# SITE DEVELOPMENT PLAN

## BLACK FOREST OFFICE

N1/2 NE1/4 SE1/4 SE1/4 OF SECTION 07, TOWNSHIP 12 SOUTH, RANGE 65 WEST OF  
THE 6TH P.M., EL PASO COUNTY, COLORADO  
4.77 ACRES

SHEET
2 OF 10

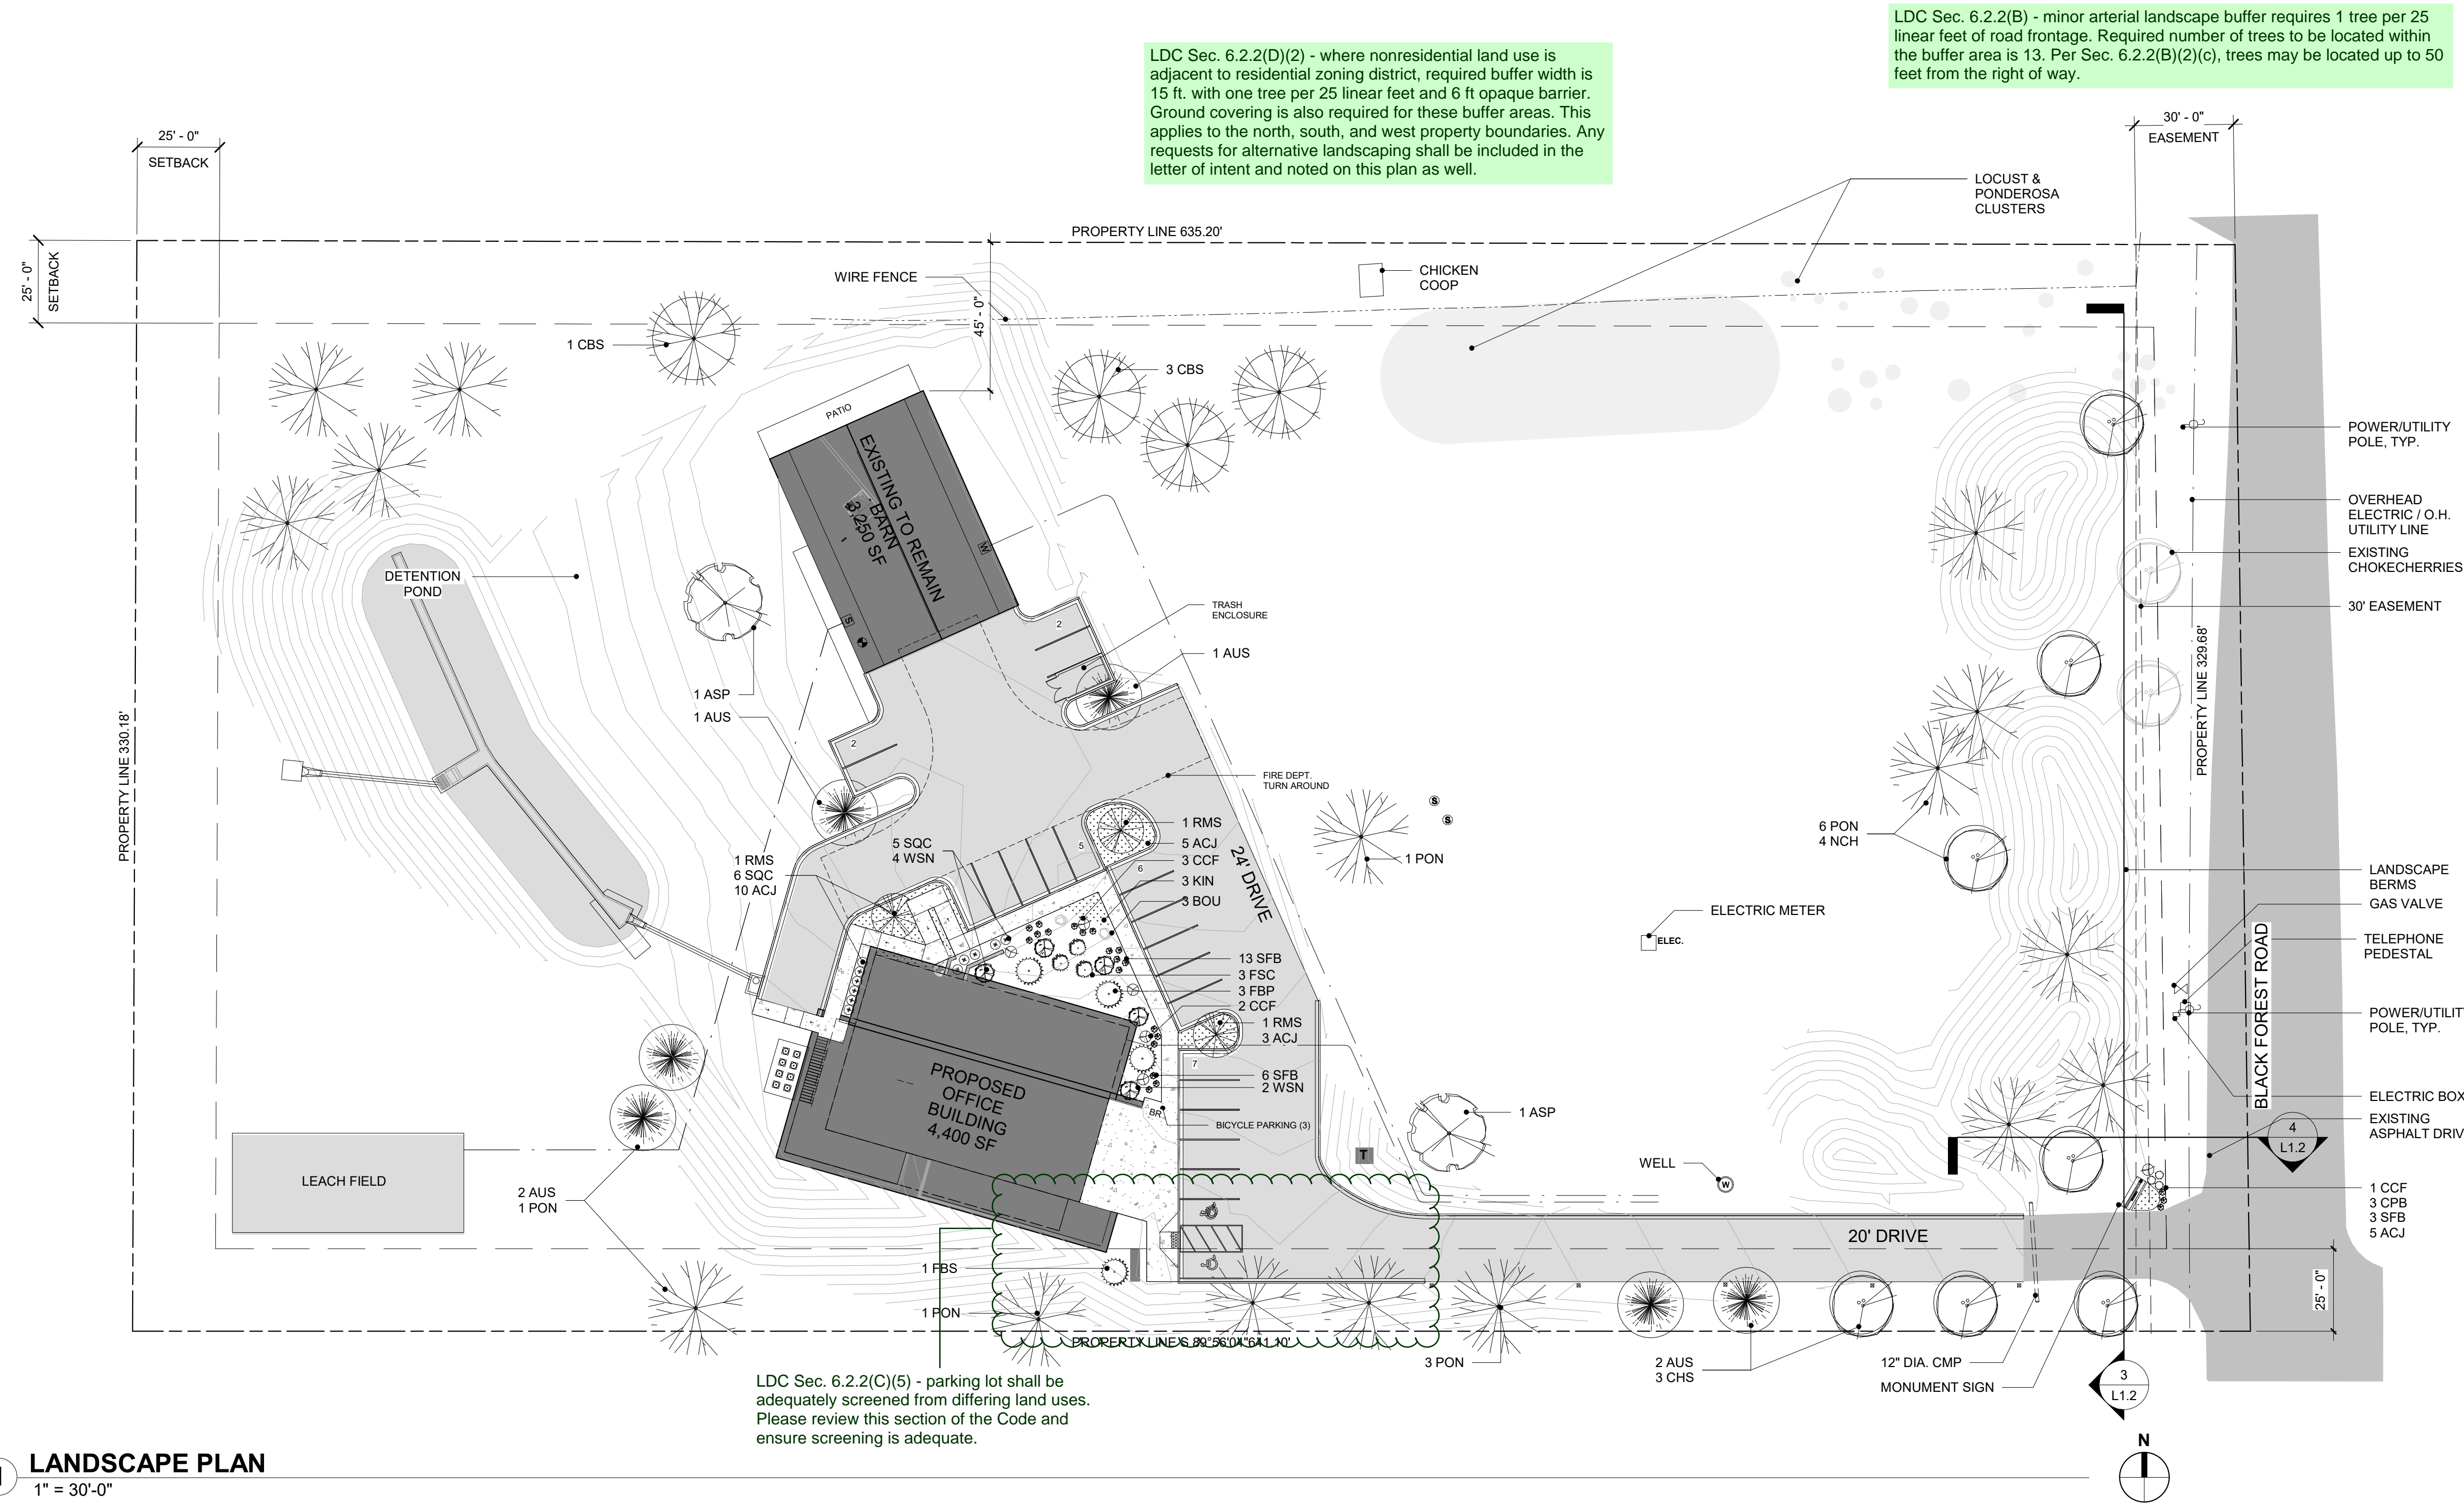
A minimum of 5% of the lot or parcel shall be landscaped. please include information on the total amount of space landscaped on the lot (in square footage)  
A minimum of one tree shall be provided for every 500 square feet of required internal landscape area. A rough estimate shows 208,000 square feet of space on the site. 5% of this must be landscaped. That value comes out to 10,400 square feet of landscaped space. approximately 21 trees required.  
provide a total tree count for the site. also provide a total shrub count.

SHEET
9 OF 10

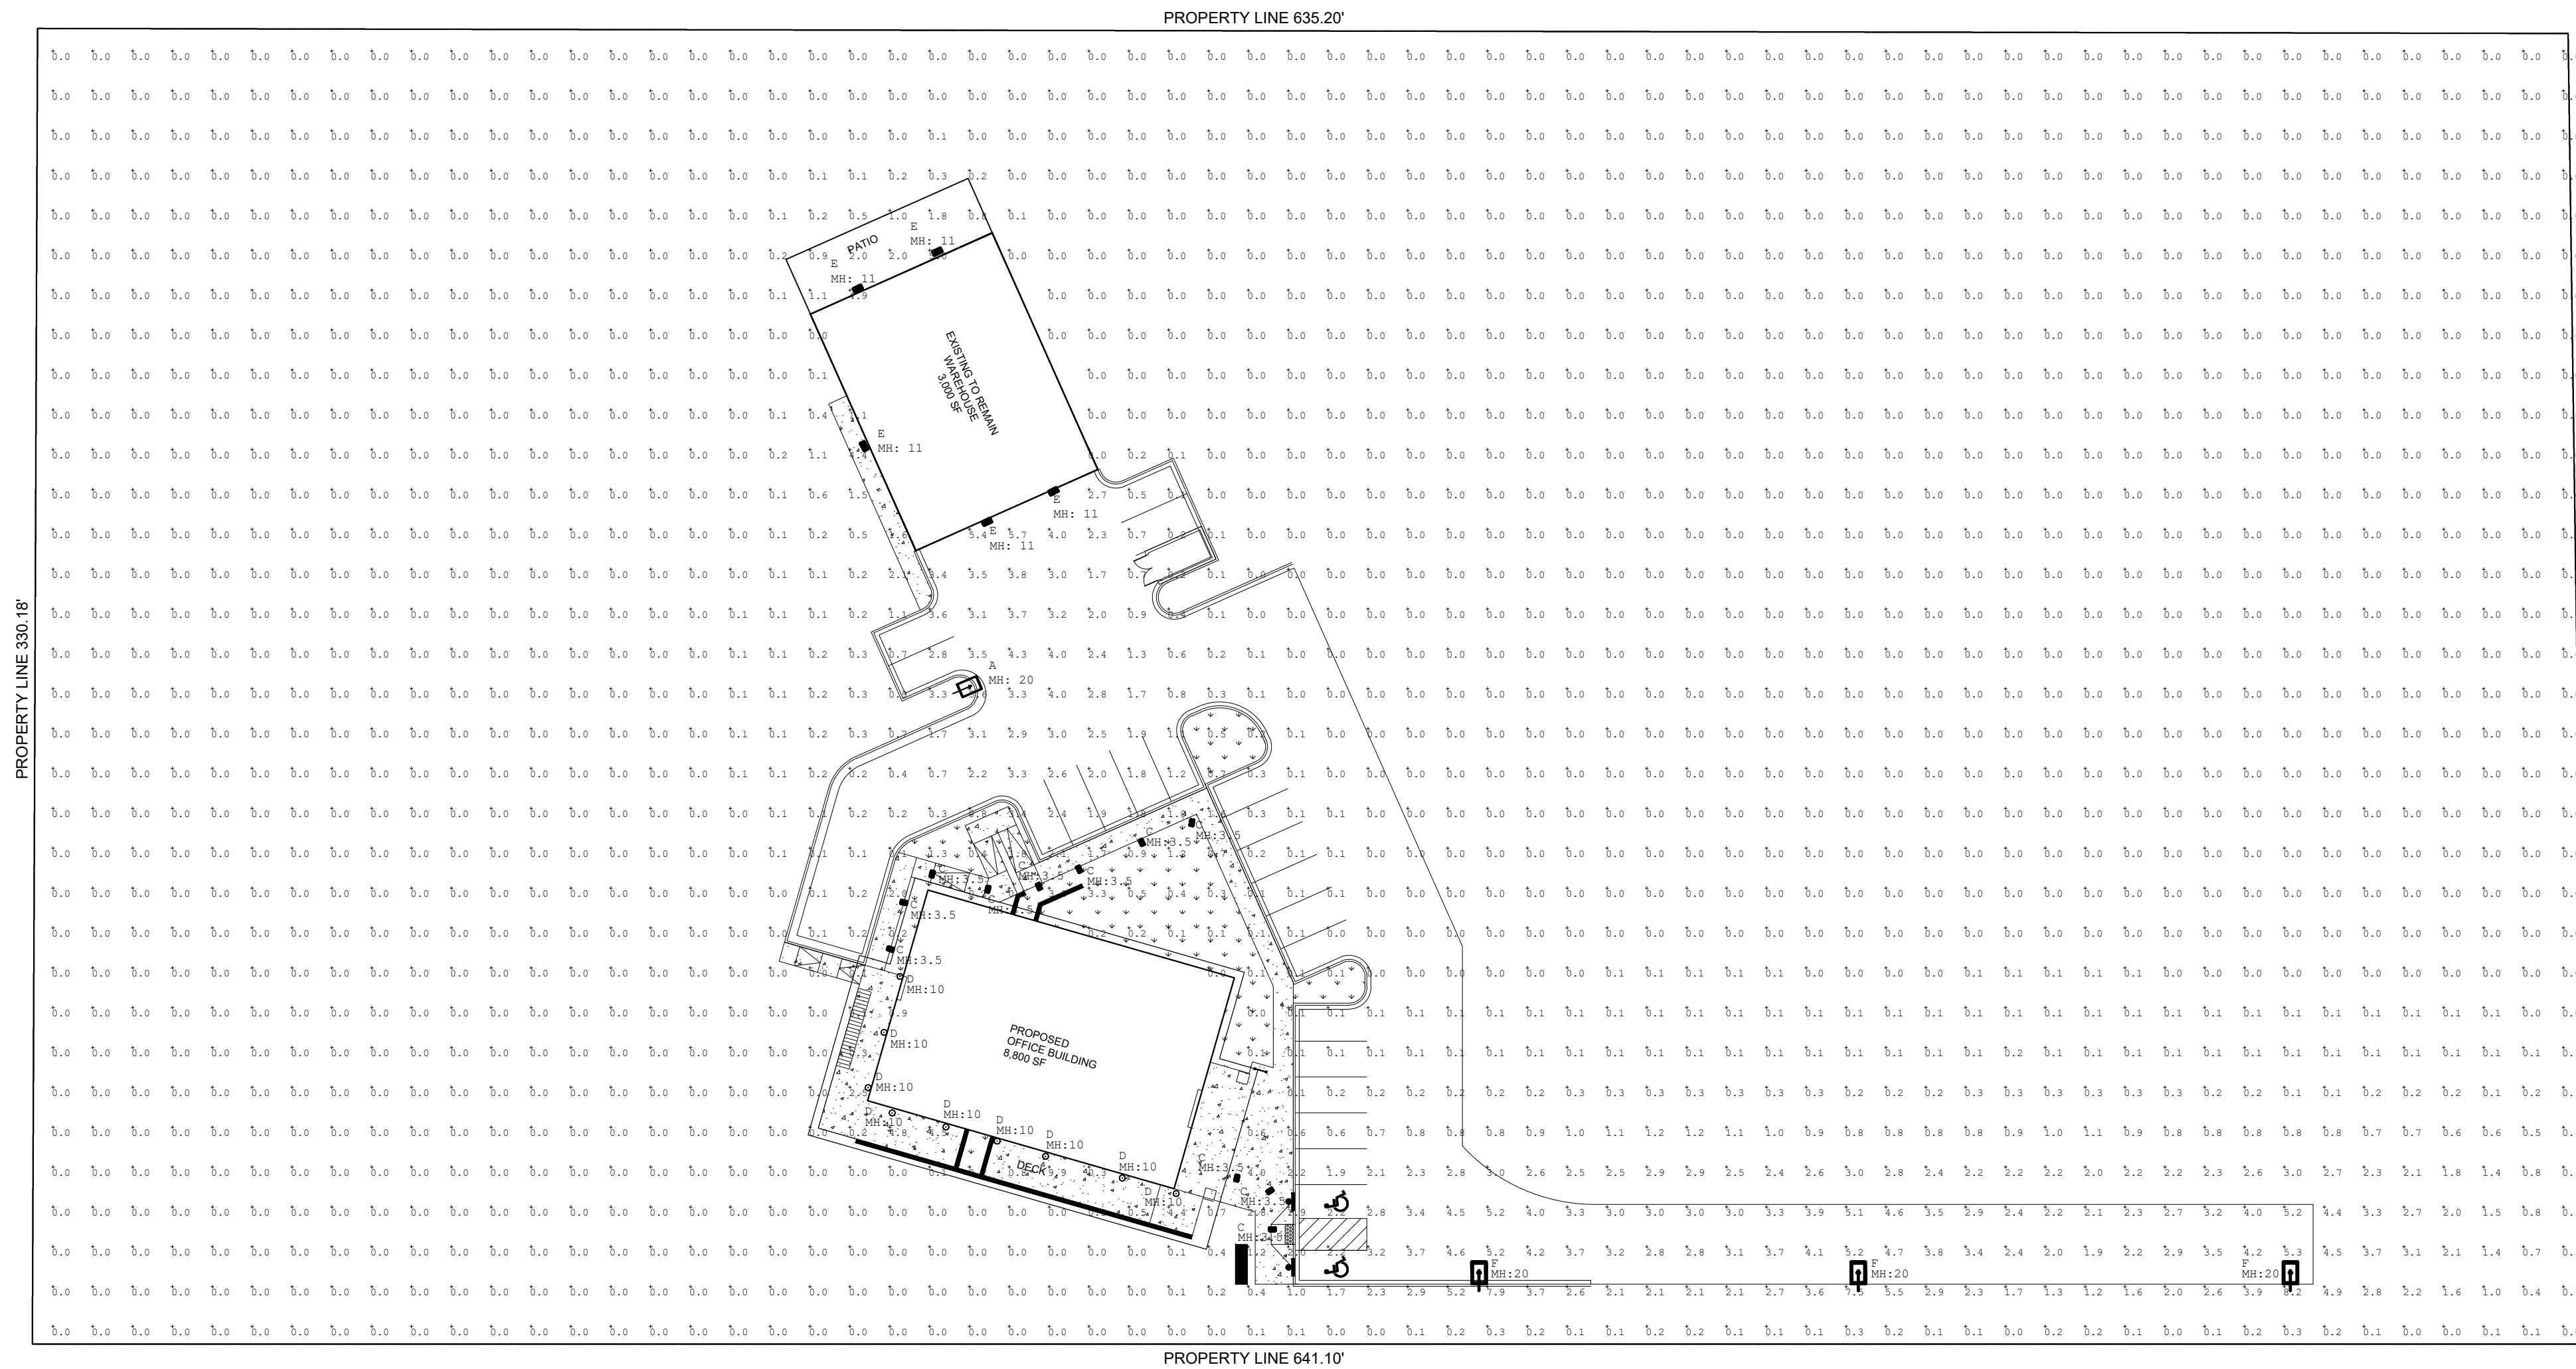
please show the setbacks of these lights, lights may not be closer than 15 feet to residential neighbors.
